Application for Planning Permission

Development: Installation of an external passenger lift. Is in CIL Zone 4 (Zero Rated) as other development.
Location: Heath Place Ash Grove Bognor Regis PO22 9SH

Block Plan - Heath Place, Ash Grove, Bognor Regis, PO22 9SH

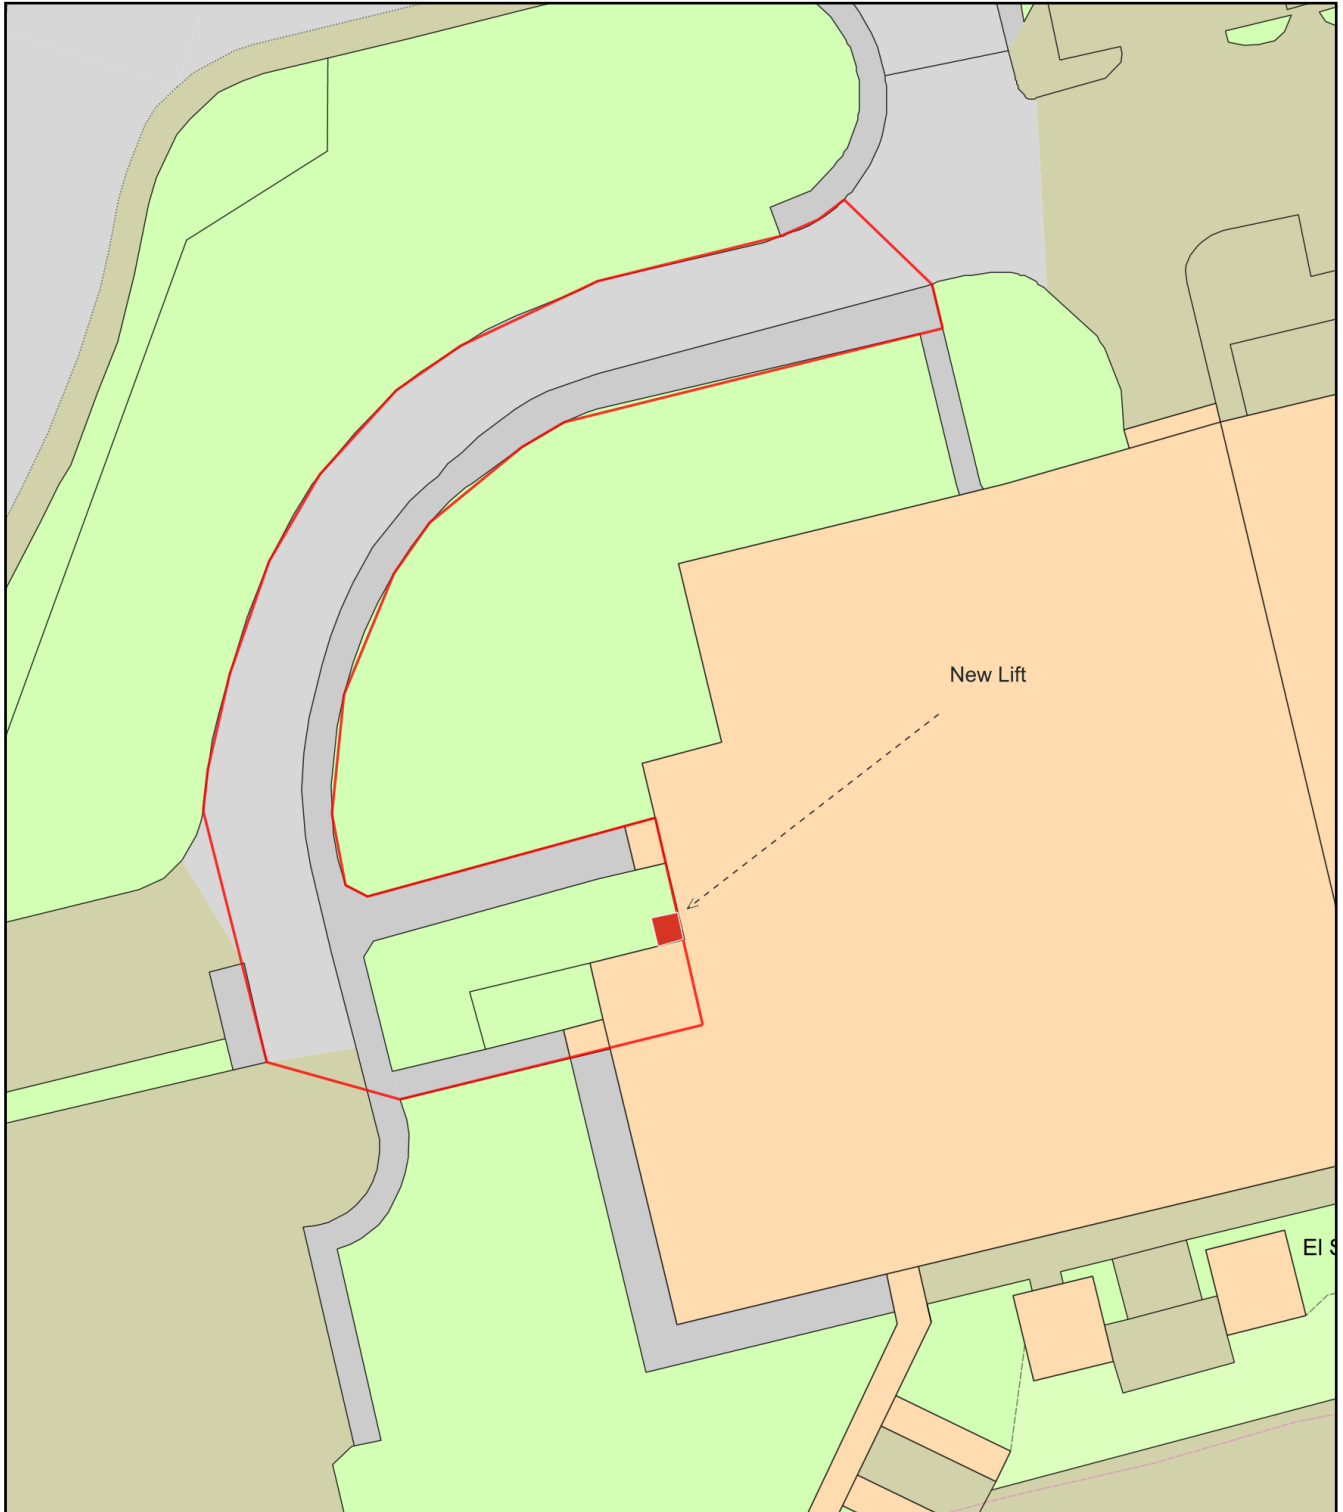
Block Plan

Please submit an electronic block plan showing the lift's position by highlighting or hatching in pdf format at a scale of 1:500. Further details of what must be included on the plan can be found in the Validation Requirements List.

# Site Location Plan - Heath Place, Ash Grove, Bognor Regis, PO22 9SH

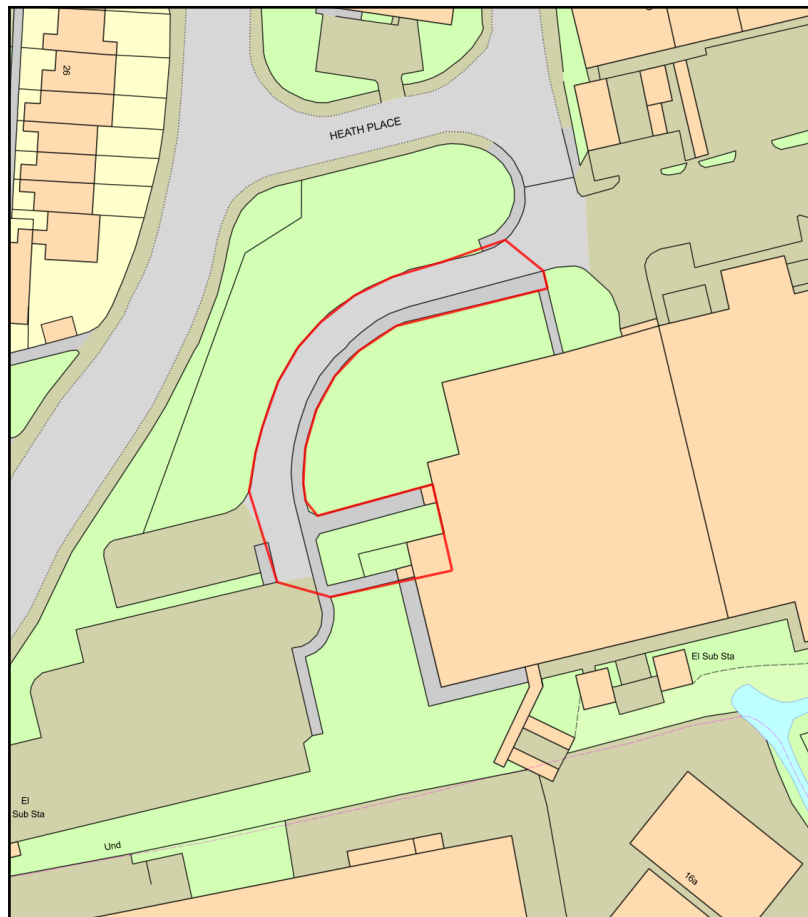
Location Plan

The location plan is not measuring correctly, please amend.
